Subject: EHG comments on a Modification Application – New Public School in Mulgoa Rise – temporary school facilities - Glenmore Park - SSD-11070211-MOD 1

Subject: EHG comments on the Modification Application for the New Public School in Mulgoa Rise – temporary school facilities – Glenmore Park - SSD-11070211 - MOD 1

- Modification report - 8 July 2022
- Appendix D – Landscape Design drawings

Drawing Title
LANDSCAPE SITE PLAN
SCALE: 1: 750 @ A3

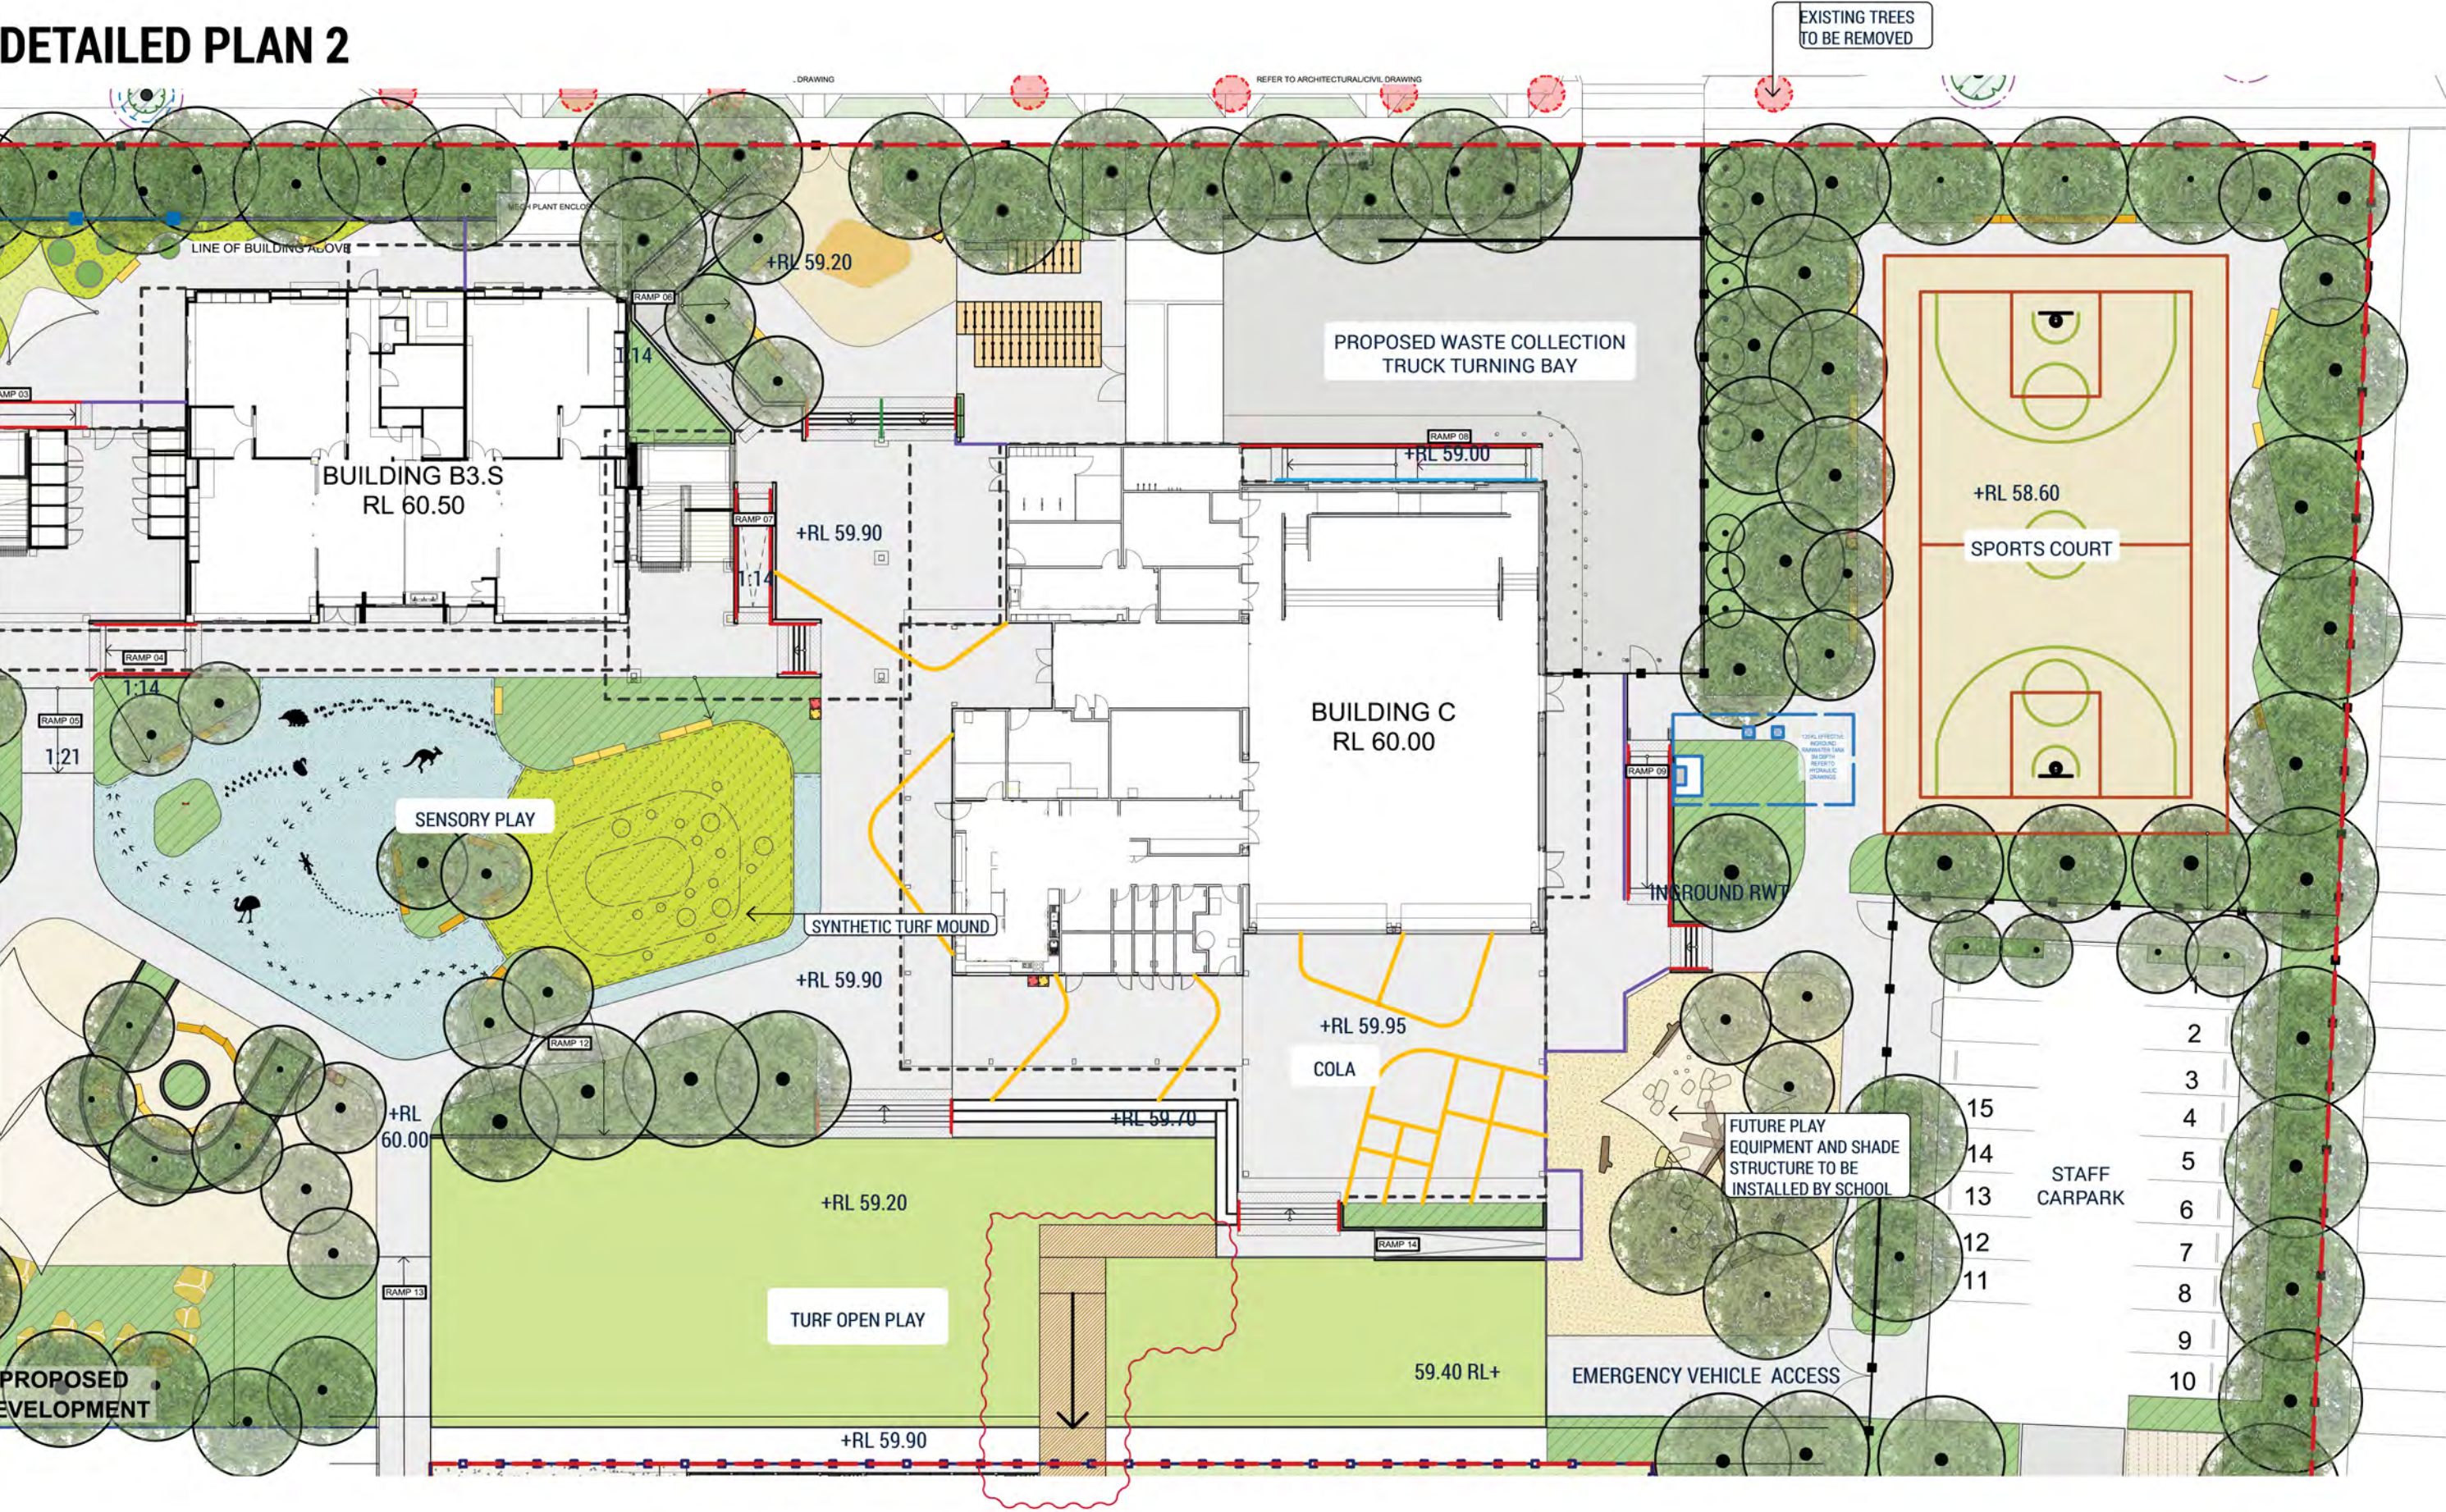
The MOD 1 report notes that no additional tree or landscaping works are proposed due to the temporary nature of the development. EHG has no issue with this due to the temporary nature of the development. Once the remainder of the permanent new school can be completed, however EHG reiterates previous advice provided by EES on the RtS for SSD-11070211 that:

- any planting / landscaping on the site uses a diversity of local provenance native trees, shrubs and groundcover species (rather than exotic species or non-local native species) from the relevant native vegetation community that once occurred in this locality particularly as the site is located near the Mulgoa Nature Reserve and Surveyors Creek Nature

- tree planting uses advanced and established native trees with a minimum plant container pot size of 100 litres, or greater for native tree species which are commercially available. Other native tree species which are not commercially available may be sourced as juvenile sized trees or pre-grown from provenance seed

- an appropriately qualified bush regenerator is engaged by the proponent to provide advice on appropriate local native species that can be used
- the school installs habitat features to improve biodiversity such as logs, bee hotels and a range of artificial nest boxes and/or (artificial hollows using a HollowHog tool (<https://www.hollowhog.com.au/>) suitable for native fauna likely to use the site particularly as the Mulgoa Nature Reserve and Surveyors Creek are located near the site.

Figure 3 Proposed Modification Site and Site Staging Plan

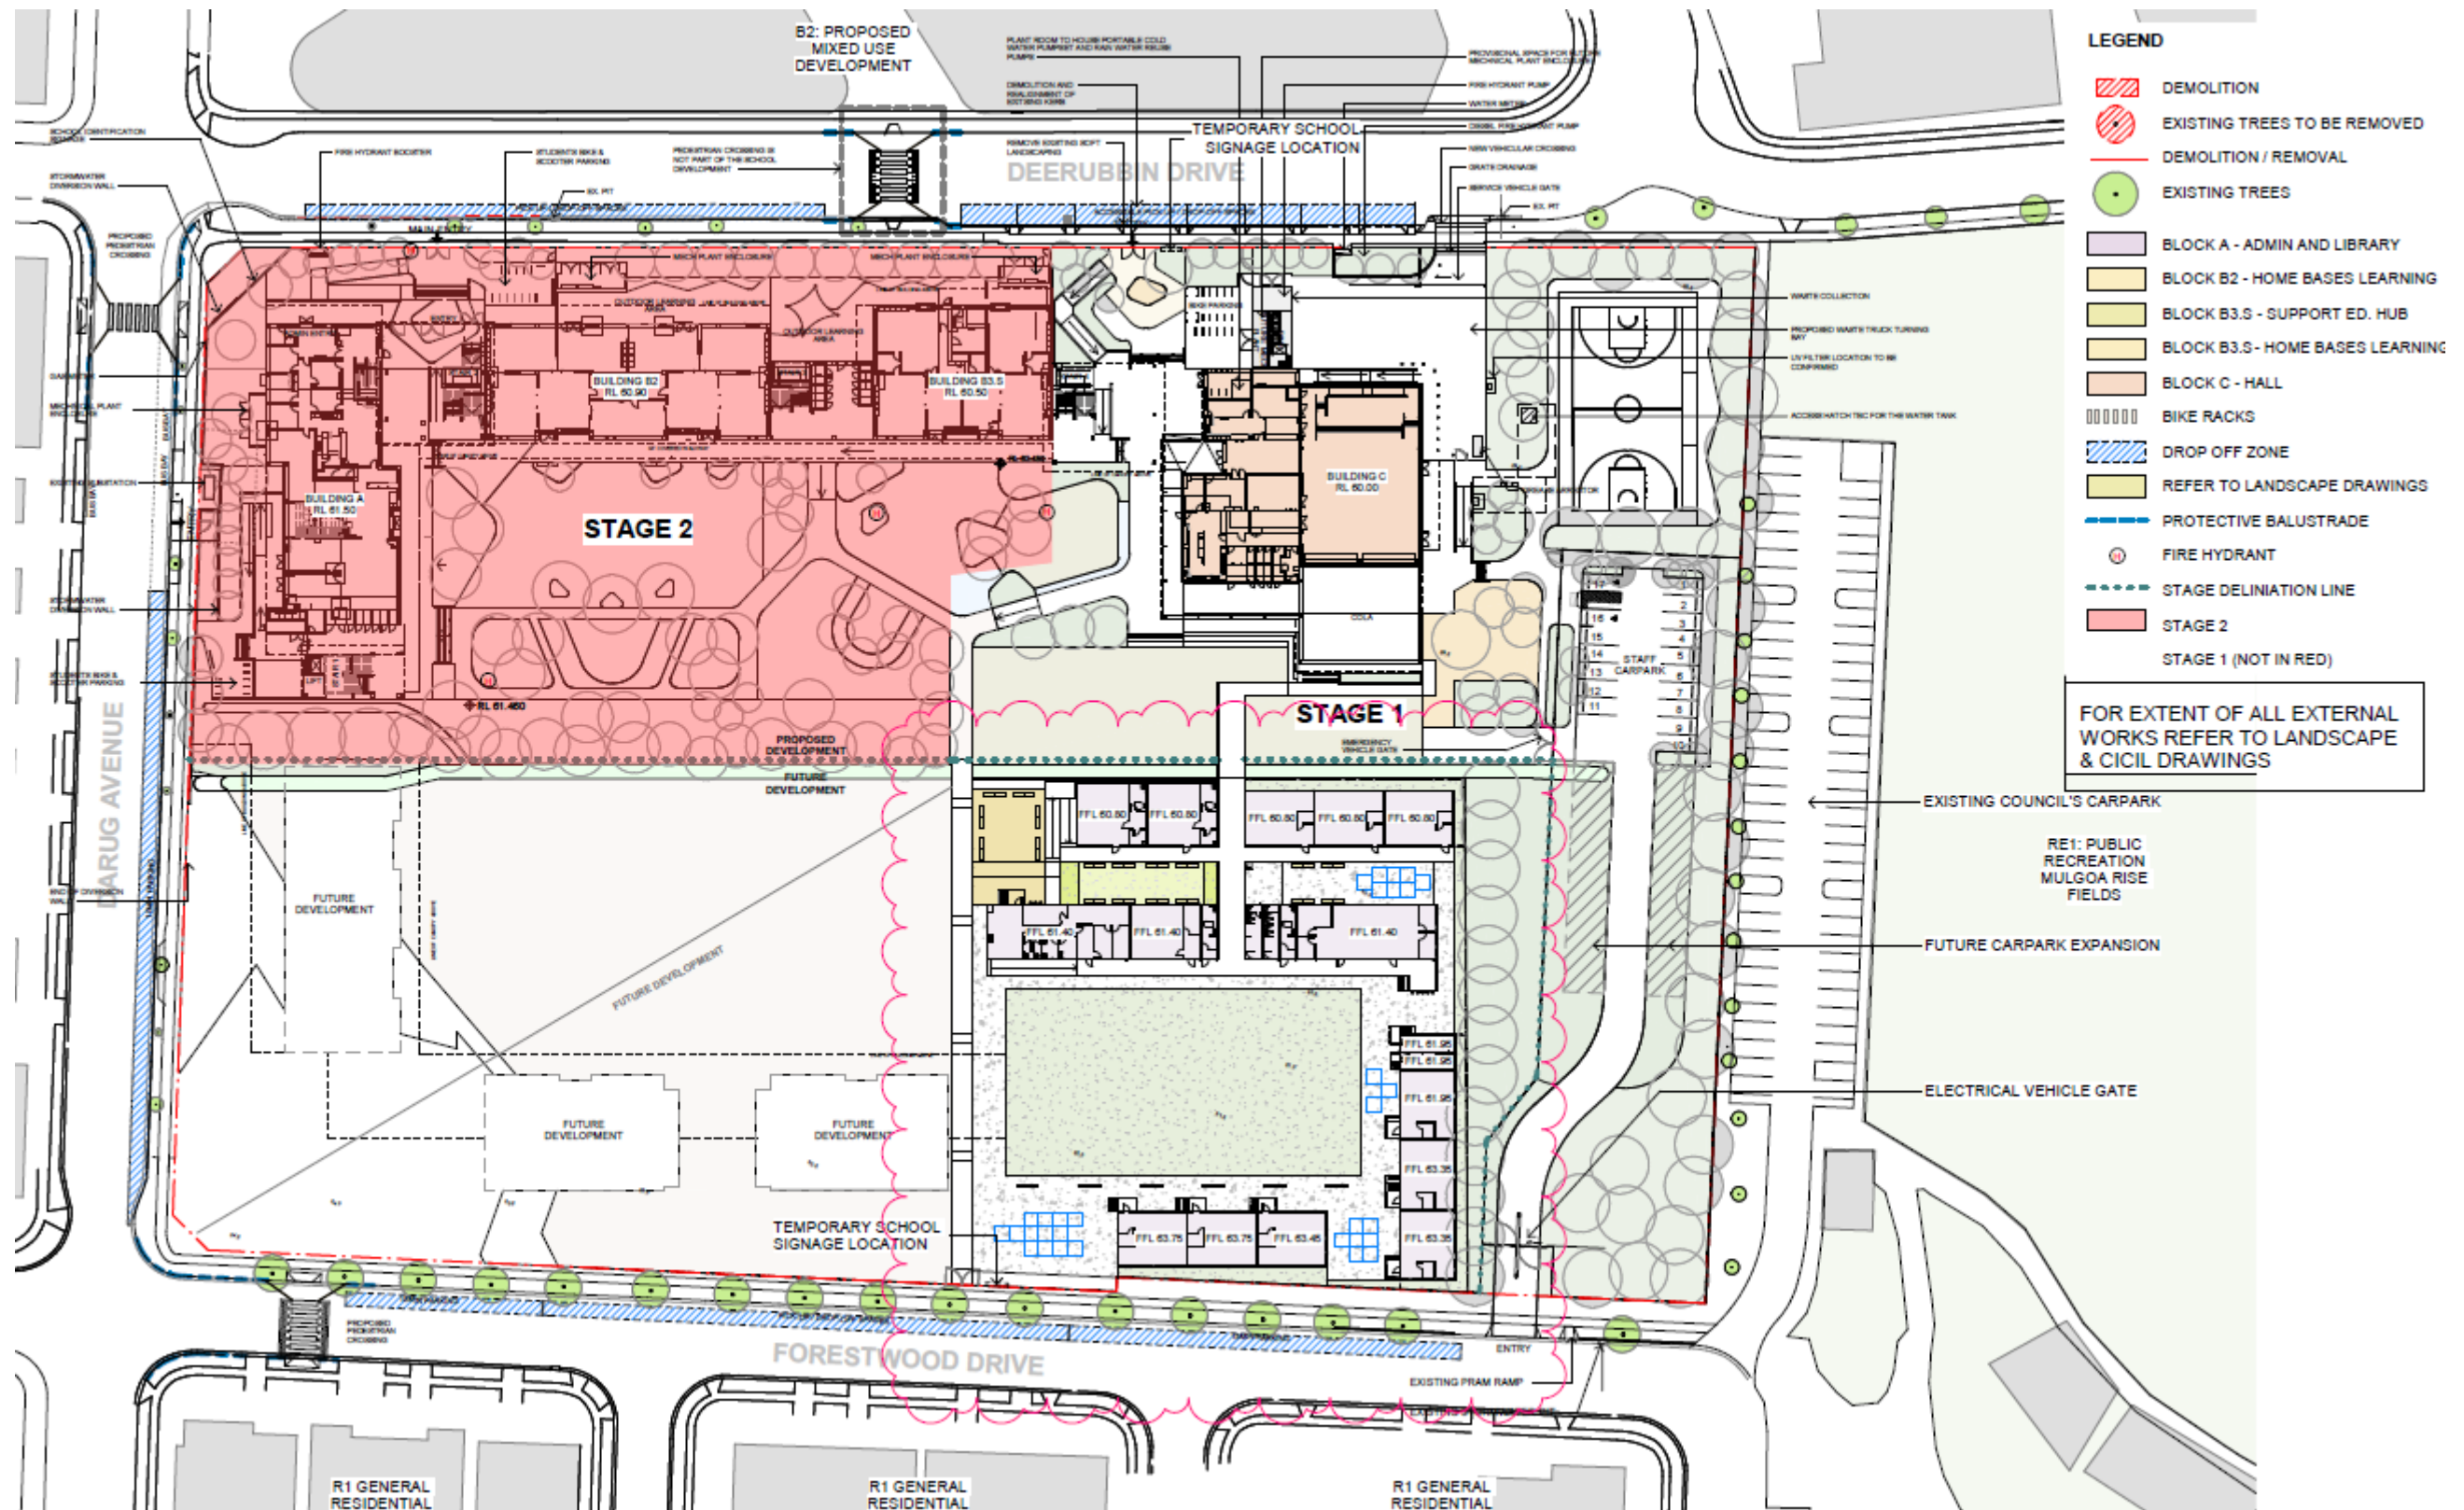
The Modification Report notes it is likely that one existing tree on Forestwood Drive may require removal and it notes it will be replaced with a tree of similar height and age once operation of the temporary school ceases (section 5.2). No other details are provided on this tree. Figure 3 in the Mod 1 report and the Landscape Site Plan in Appendix D do not appear to locate this tree to be removed as part of the MOD 1 proposal. The figure/plan only shows the two trees that were identified on Forestwood Drive for removal as part of SSD-11070211.

As noted in the EES submission on the EIS for SSD-11070211, the EIS indicates the road reserve surrounding the proposed development footprint currently consists of two different species of newly planted exotic street trees (Chinese Elm and Manchurian Pear). It is unclear if the additional tree that may be removed as part of MOD 1 is a Chinese Elm (*Ulmus parvifolia*). As advised in the EES submission on the EIS, Chinese Elm is listed as a weed in Appendix 2 of the *Greater Sydney Local Land Services (2017) Greater Sydney Regional Strategic Weed Management Plan 2017-2022* as it poses a potential risk to the environment.

EHG reiterates if there is any potential for this species to spread from the road reserve to the nearby Mulgoa Nature Reserve or Surveyors Creek, it is recommended this species is removed and replaced by a mix of local native tree species. At the very least any trees to be planted to replace the trees removed as part of SSD-11070211 and the MOD 1 proposal should be a mix of local native tree species rather than exotic species.

It is recommended the 'Additional Mitigation Measures' in the MOD 1 report which relate to 'Trees' is amended to include a measure that if the existing tree is removed it is replaced with a local native tree species of similar height and age once the operation of the temporary school ceases.
